**From:** Tom Errico <thomas.errico@tylin.com>  
**To:** Jean Fraser <JF@portlandmaine.gov>  
**CC:** David Margolis-Pineo <DMP@portlandmaine.gov>, Katherine Earley <KAS@portlandmaine.gov>, Jeremiah Bartlett <JBartlett@portlandmaine.gov>, Jeff Tarling <JST@portlandmaine.gov>, Michael Farmer <Mfarmer@portlandmaine.gov>  
**Date:** 11/7/2013 12:47 PM  
**Subject:** 133 York Street

Jean - The following are my final comments and represent a status update of my August 23, 2013 comments.

## Passenger Car at 5 mph, Space 1

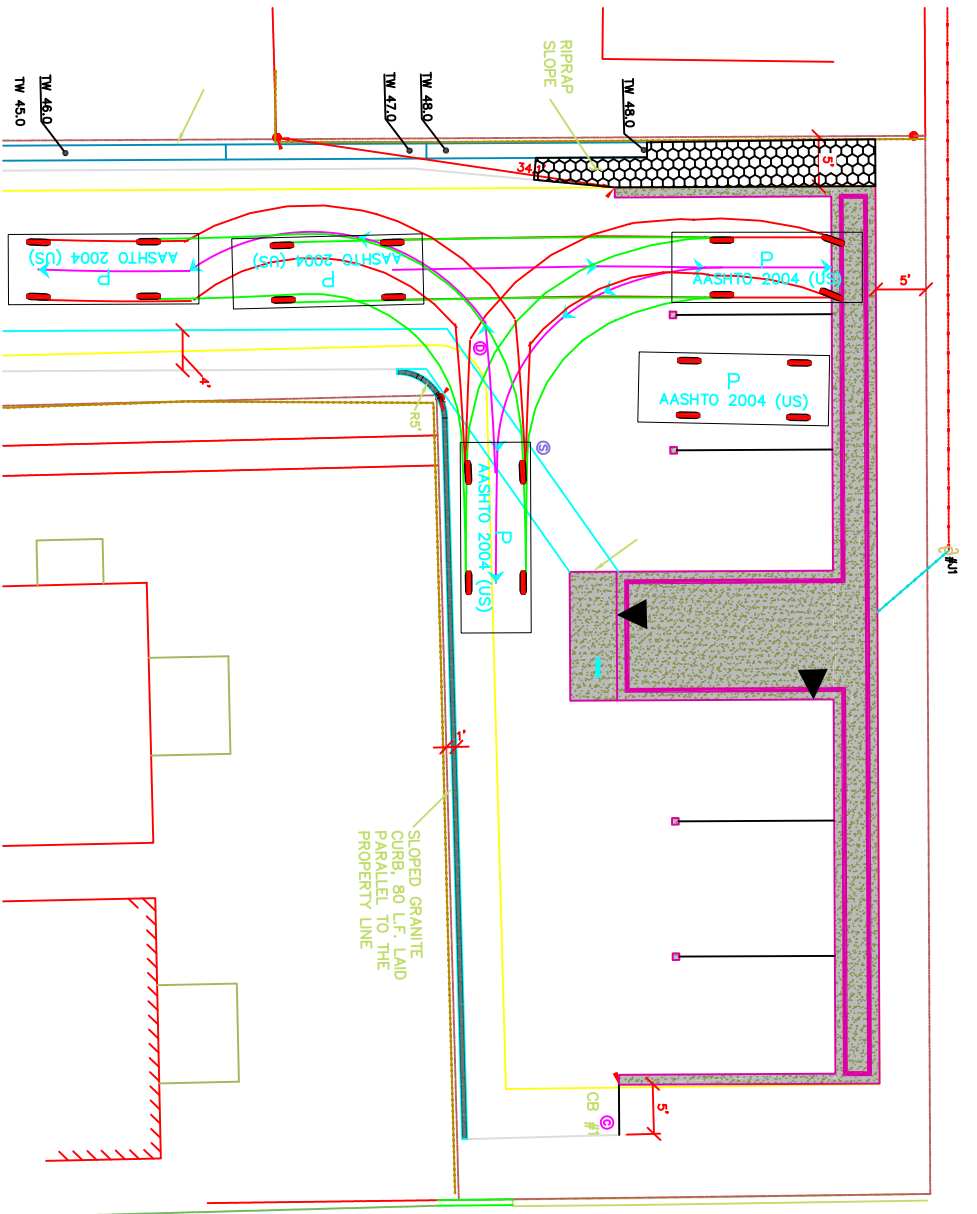
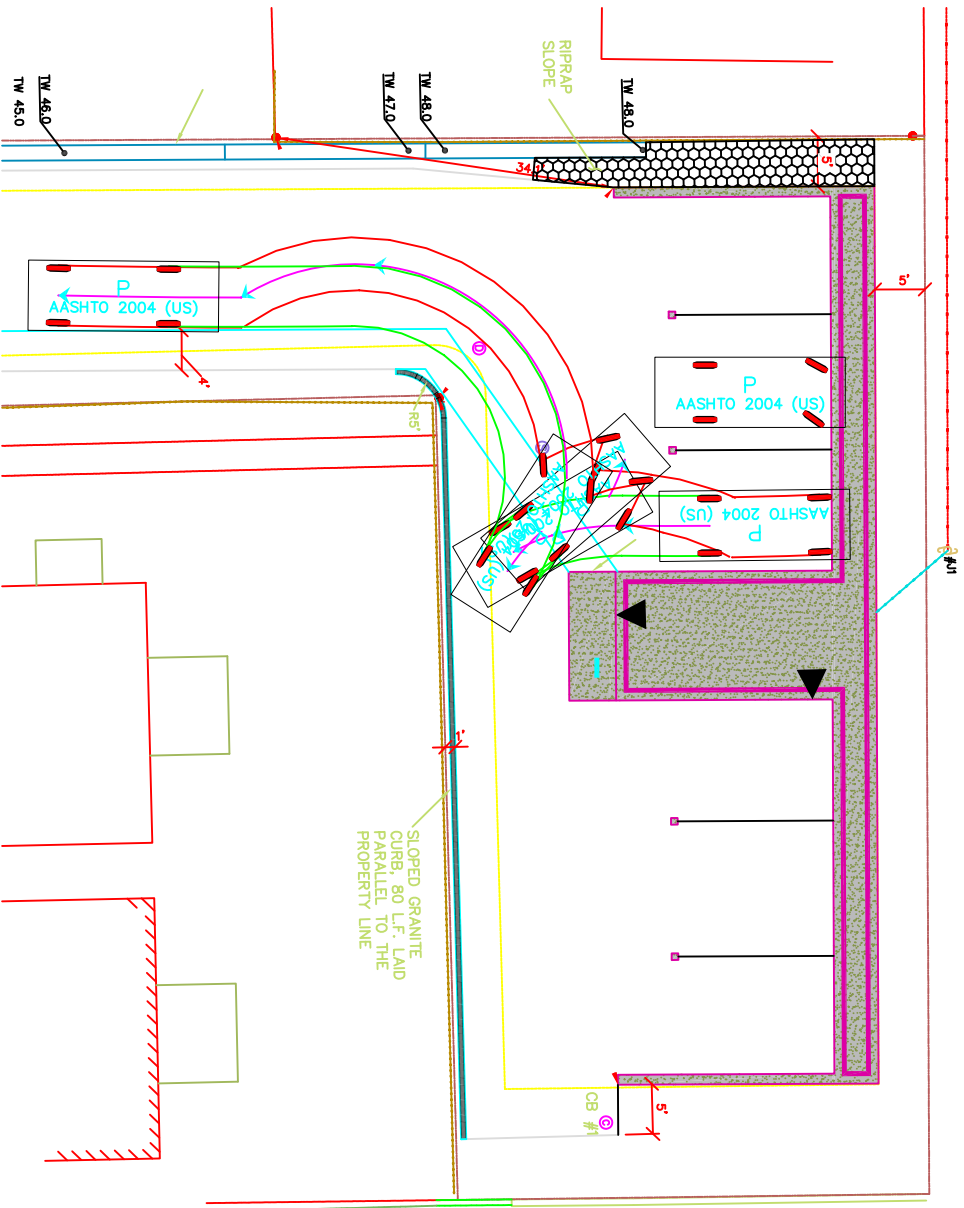
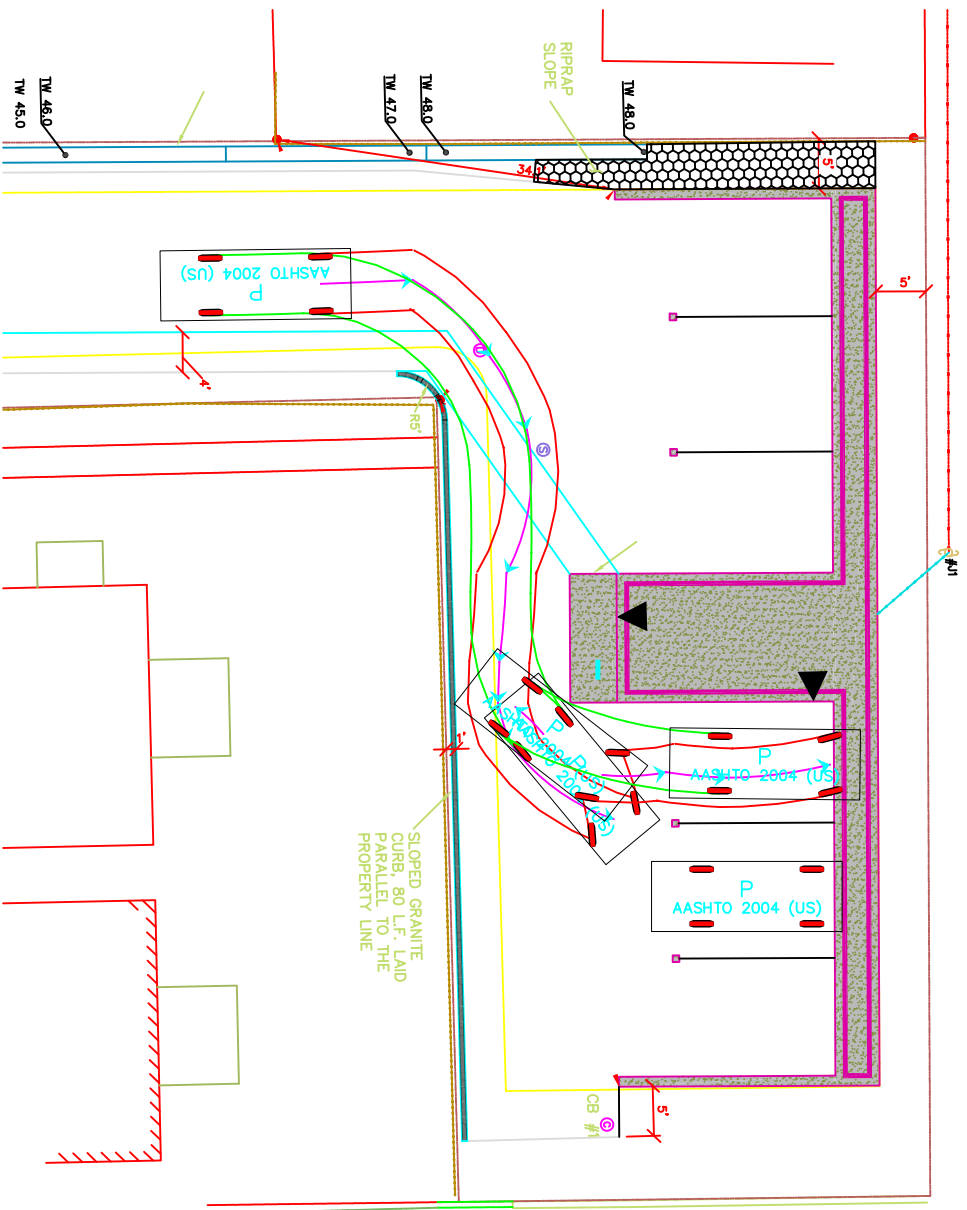
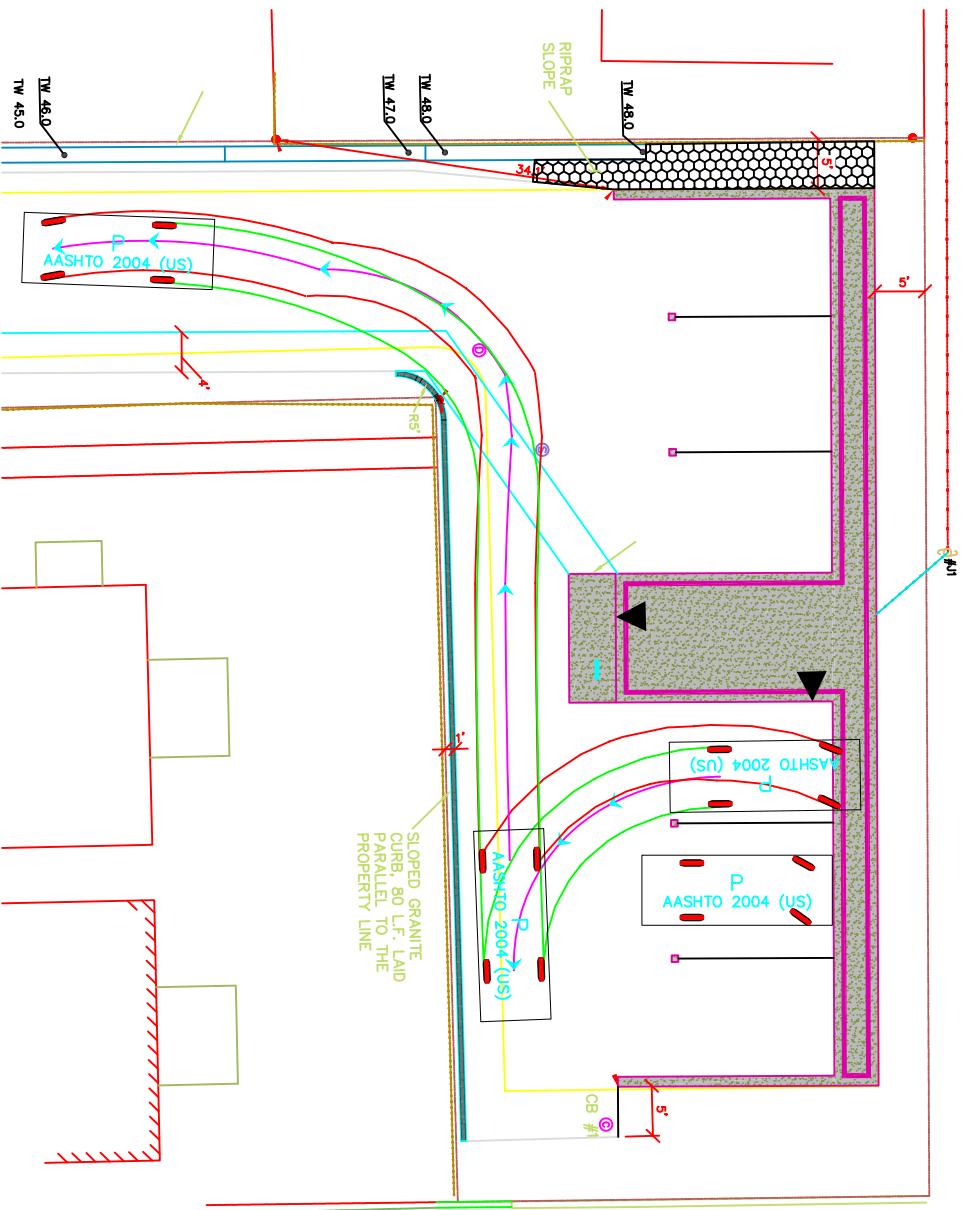
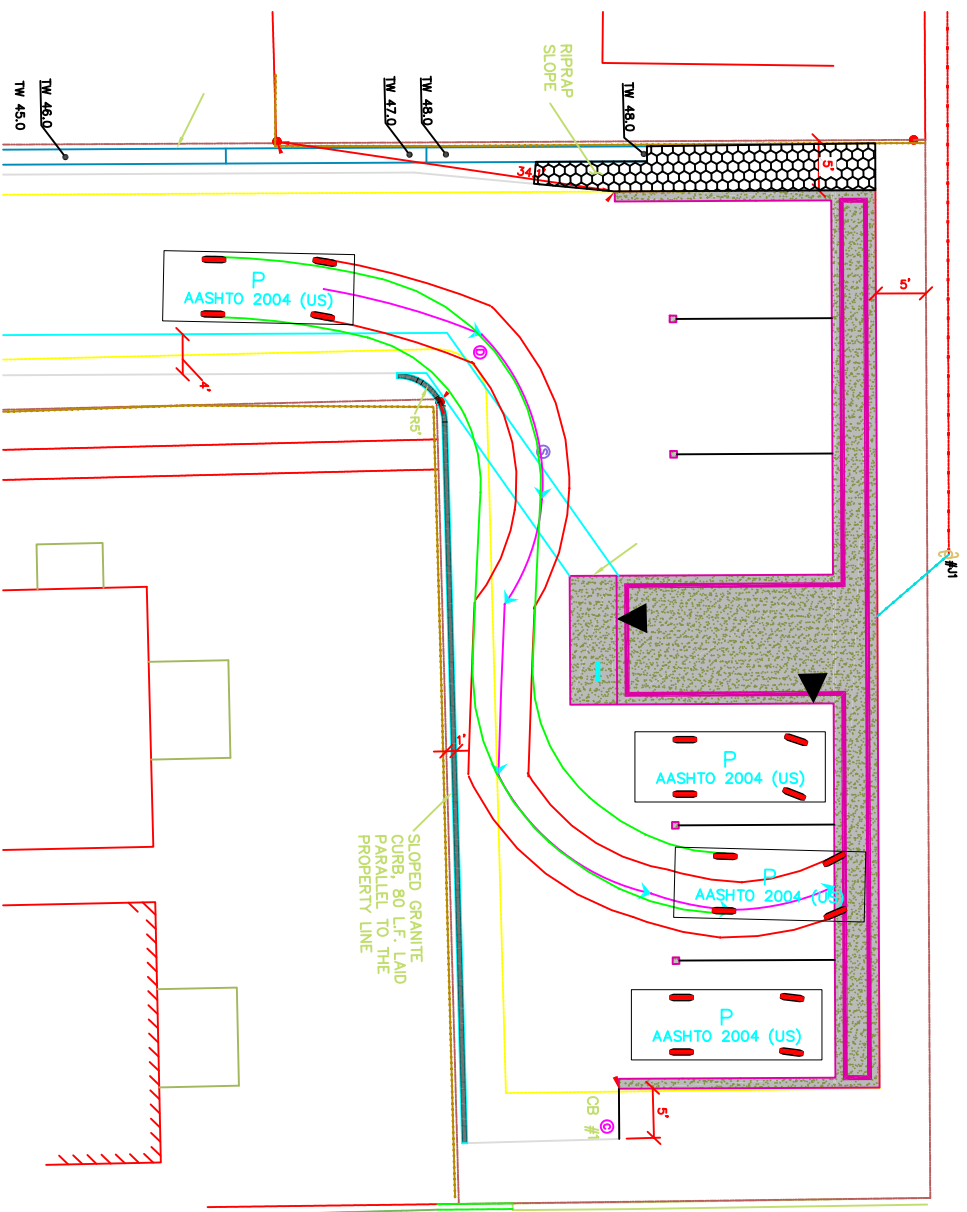
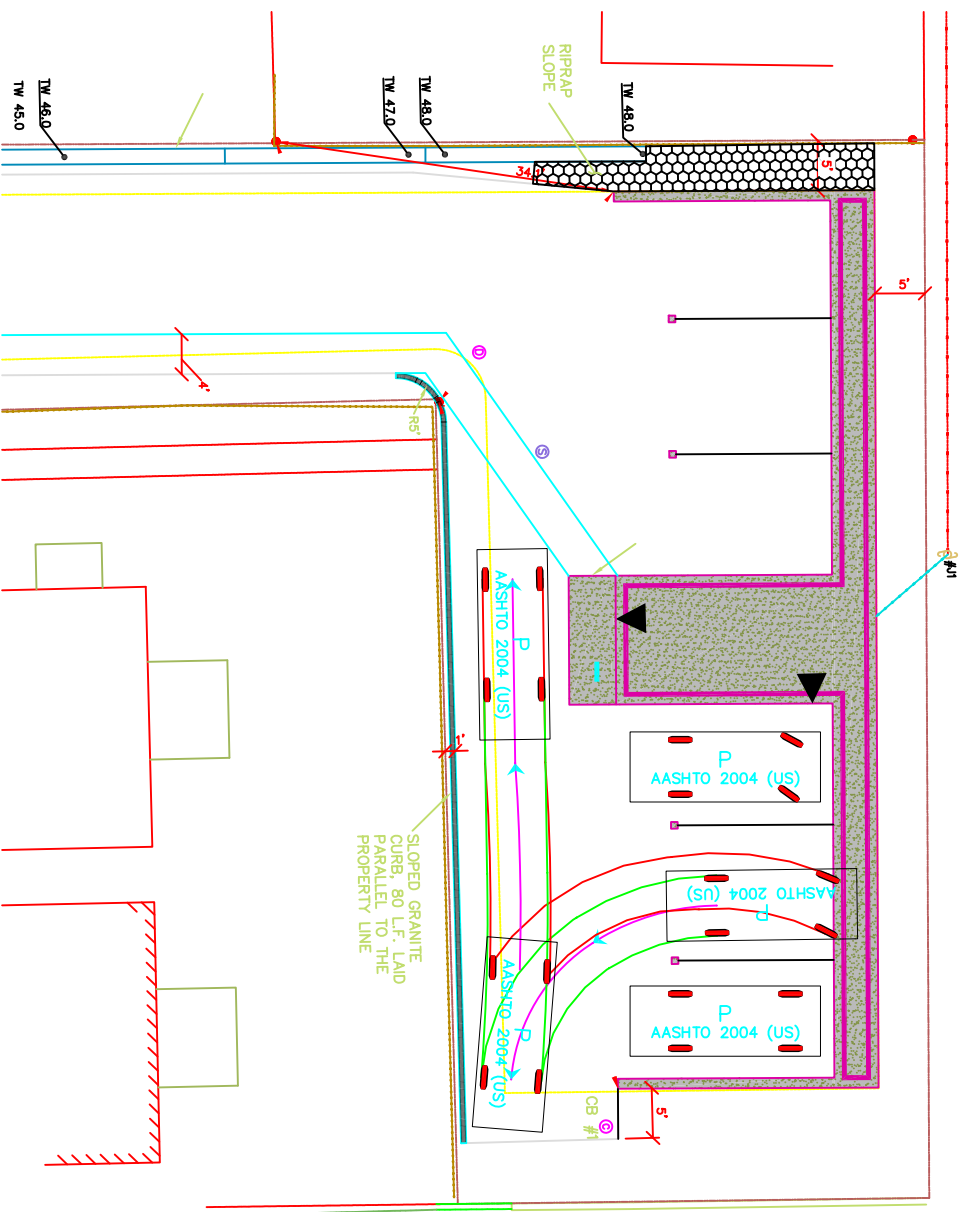
\* Access and egress movements into the garages appear difficult given the narrow pavement area. The applicant shall provide turning template graphics for a standard passenger car illustrating the ability of vehicles to adequately circulate on-site.

**Status: The applicant has provided the requested turning template graphics. Given site constraints, I also requested that the applicant provide a simulated site layout in a parking area so that I could determine if vehicles could access/egress the parking garages. Based upon the field study, some garages will require multiple maneuvers (k-turns) to enter and exit the garages. The site is very constrained and the ease in which vehicles can make their intended maneuver will be a function of the design vehicle. My field simulation was based upon a Subaru station wagon and this represents a mid-size vehicle. Large Single-Unit Vehicles (SUV) will have greater difficulty. With all that said, I do support a waiver from our technical standards for parking lot aisle width dimensions. The waiver is suggested given the unlikelihood that vehicles will back down the driveway into York Street. There is a significant distance between the garages and York Street, and thus feel that all maneuvers will occur on-site. I would note that the bicycle rack should be relocated so that it does not impede circulation. Additionally, it will be very important that snow removal/maintenance is effective so that snow does not further constrain the site.**
